September 8, 2020

**Re: Laundromat TI**  
**12910 Indian School Road NE**  
**Traffic Circulation Layout**  
Architect's Stamp 08-27-2020 (J22-D052)

3 **HANDICAPPED RAMP DETAIL**
TCL NOT TO SCALE

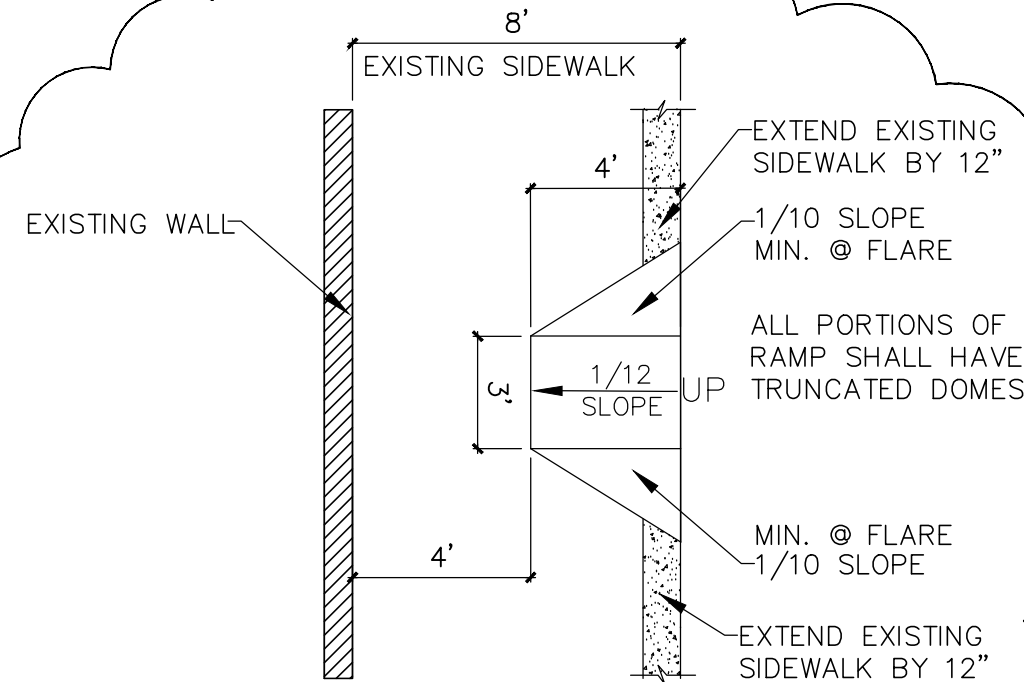
5. ADA curb ramps must be updated to current standards (**existing and proposed**) and have **truncated domes installed**. Provide detail.
6. Motorcycle parking space: Label pavement MC.

TRAFFIC
CIRCULATION
LAYOUT

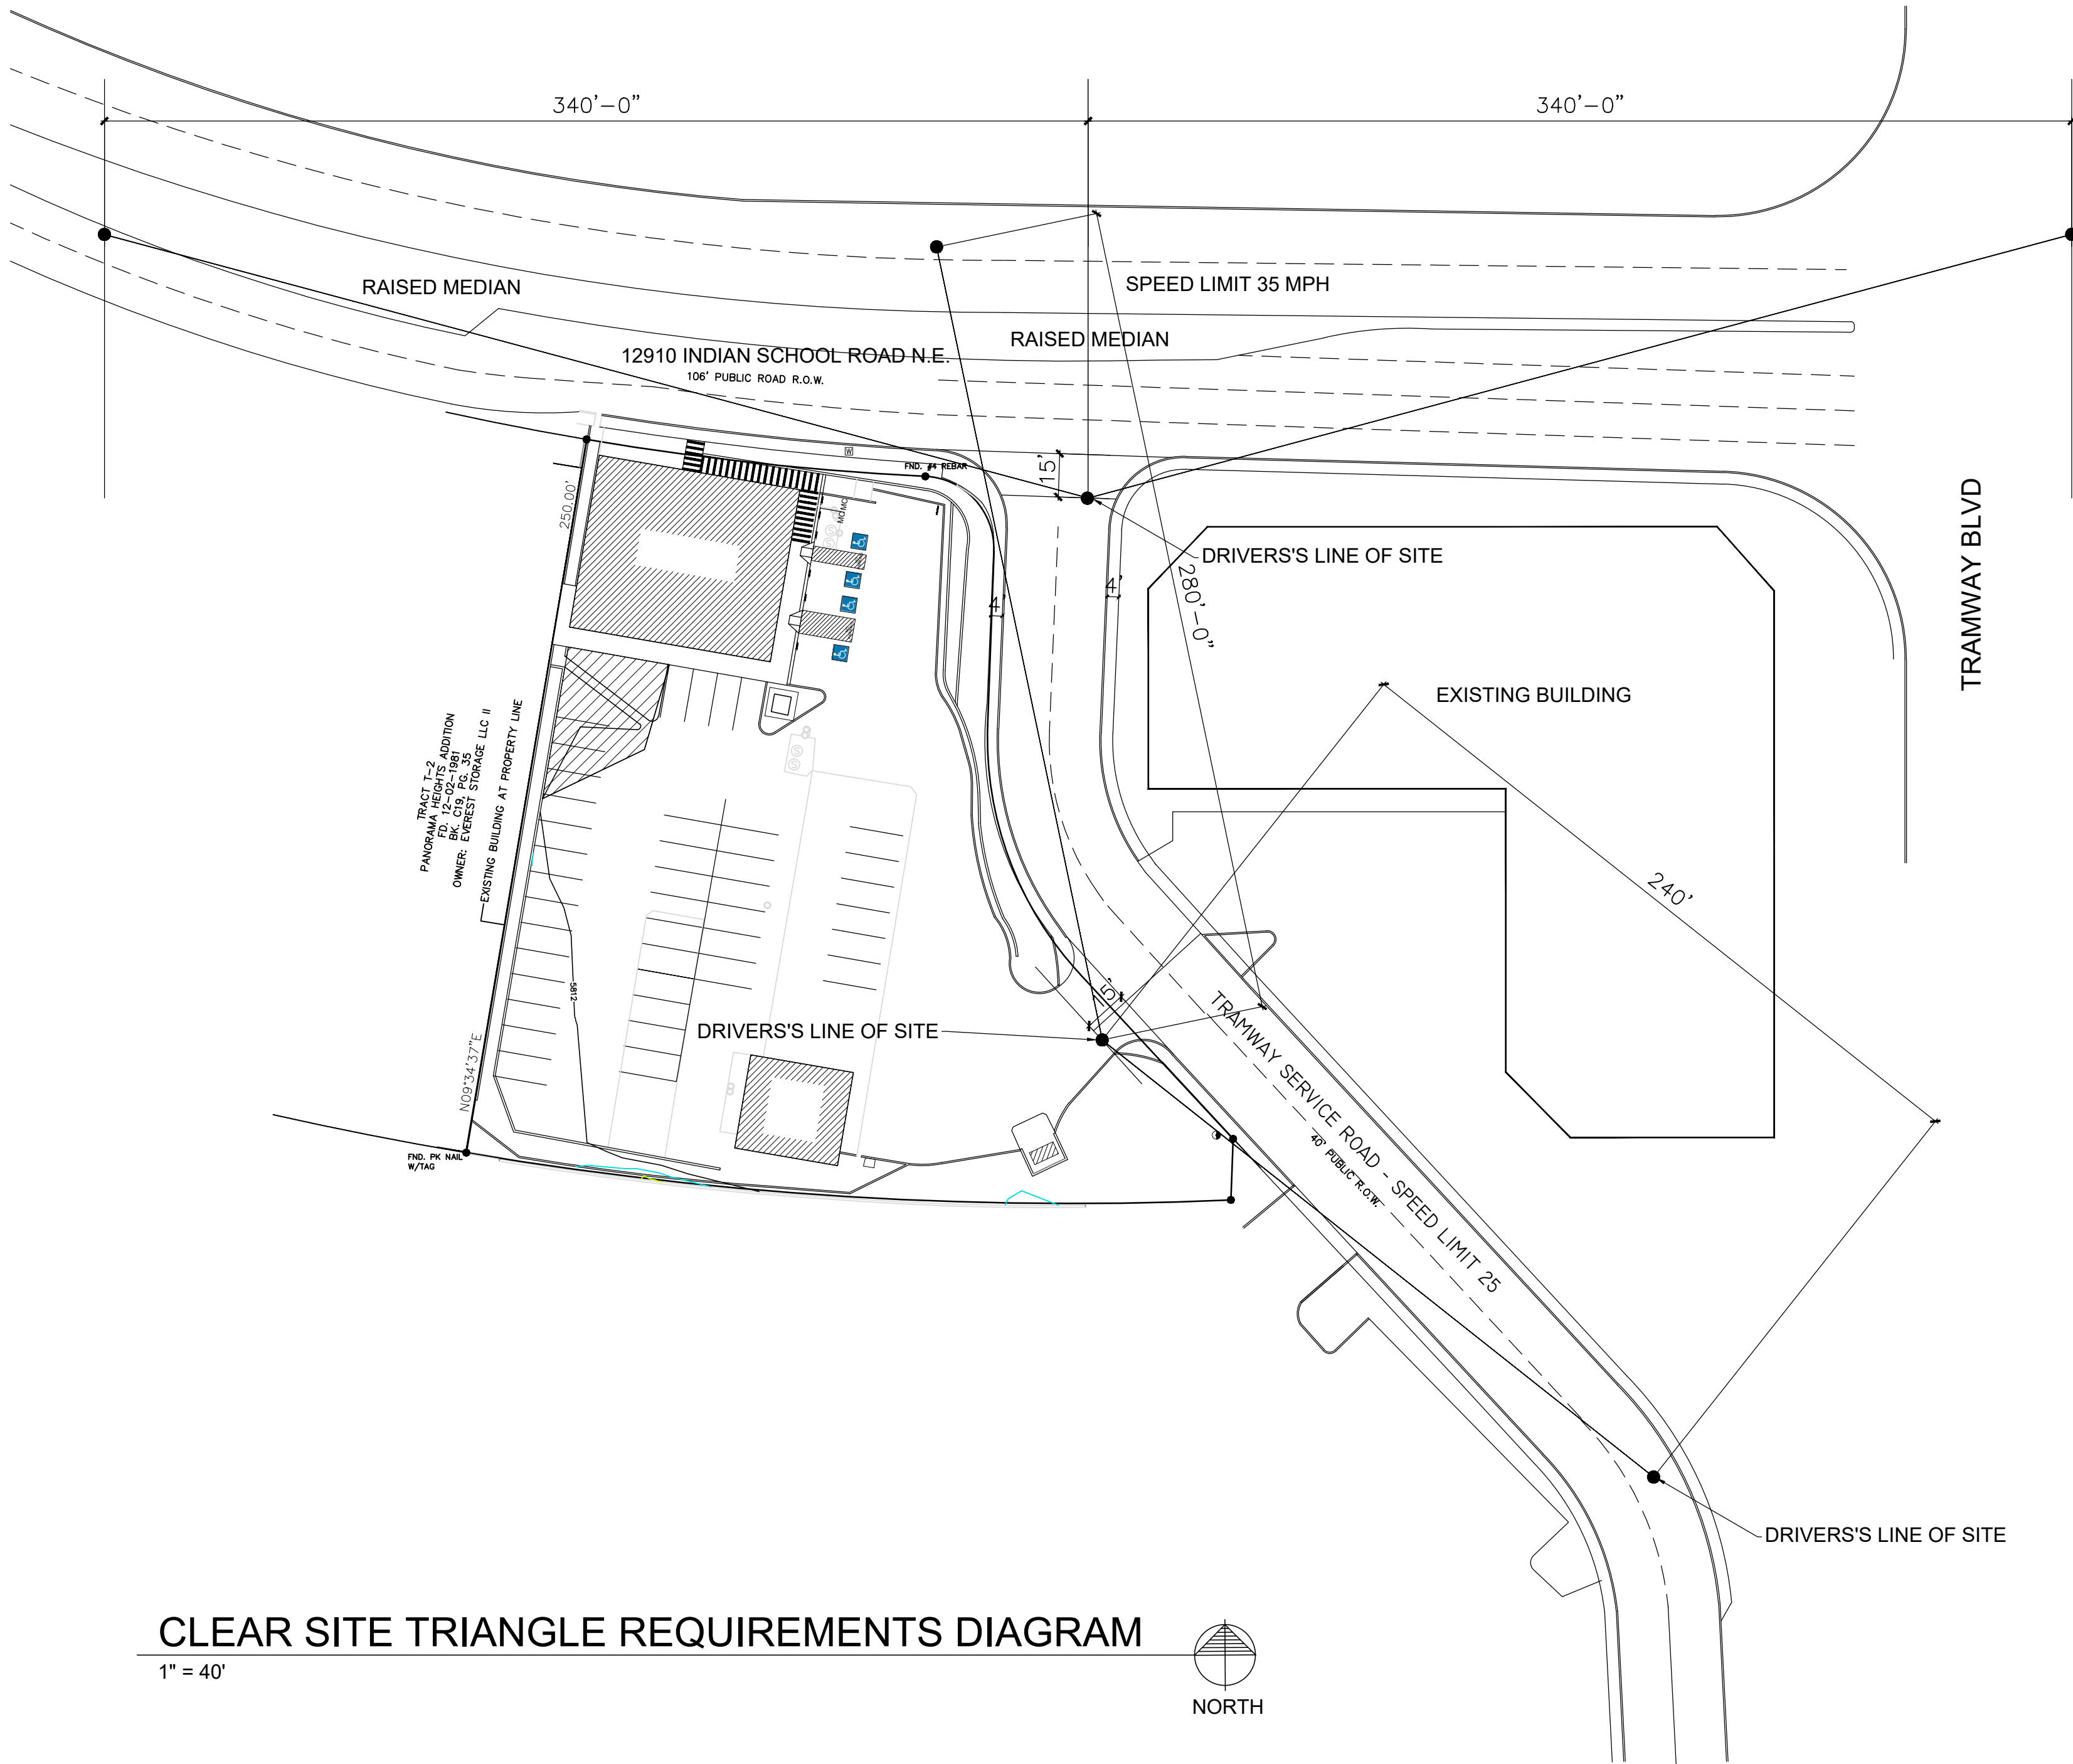
1. Please show a vicinity map showing the location of the development in relation to streets and well known landmarks.
2. Existing public sidewalks: Existing widths need to be shown on Indian School and Tramway Service road.

3. Indian School and Tramway Service Road: All three of the existing ramps not not ADA curb ramps must be updated to current standards and have **truncated domes installed**. Provide new ramps and detail for each. You can use COA std dwg 2426 and 2441 instead of a detail.

4. The ADA accessible spaces must include an access aisle. Van accessible aisles should be 8ft wide; all others should be 5ft wide. How does the 5 ft aisle obtain access onto the 7 ft sidewalk without a proposed ramp?

7. Show all drive aisle widths and radii. Some dimensions are not shown.
8. Per the IDO, a 6 ft. wide ADA accessible pedestrian pathway (Label on Site Plan) is required from the public sidewalk to the building entrances. **Please clearly show this pathway and provide details**. If a pedestrian pathway is existing it must be 6 feet in width and NO BROKEN OR CRACKED SIDEWALK.

9. ADA parking stall access aisles to the building entrances: ADA ramp must be provided and have a turnaround landing of 4 ft width contained within the 7 feet sidewalk fronting building.

10. Refuse vehicle maneuvering shall be contained on-site. The refuse vehicle shall not back into the public right of way.; **provide a copy of refuse approval**.

11. Show the clear sight triangle and add the following note to the plan (**For existing landscaping at Tramway Service Road entrance**): "Landscaping and signage will not interfere with clear sight requirements. Therefore, signs, walls, trees, and shrubbery between 3 and 8 feet tall (as measured from the gutter pan) will not be acceptable in the clear sight triangle."

12. Some of the proposed keyed notes (13, 14 & 22) are missing on site plan. Please provide.
13. Add a note stating "All broken or cracked sidewalk must be replaced with sidewalk and curb & gutter." A build note must be provided referring to the appropriate City Standard drawing (2430 & 2415).

14. Existing concrete and asphalt pavement within parking aisle and area will need to be resurfaced since concrete is damaged and asphalt torn up from the removal of the car wash. This will need to be addressed, especially concrete.

15. The southern property portion appears to have some easement not shown on plans. This will need to be addressed.
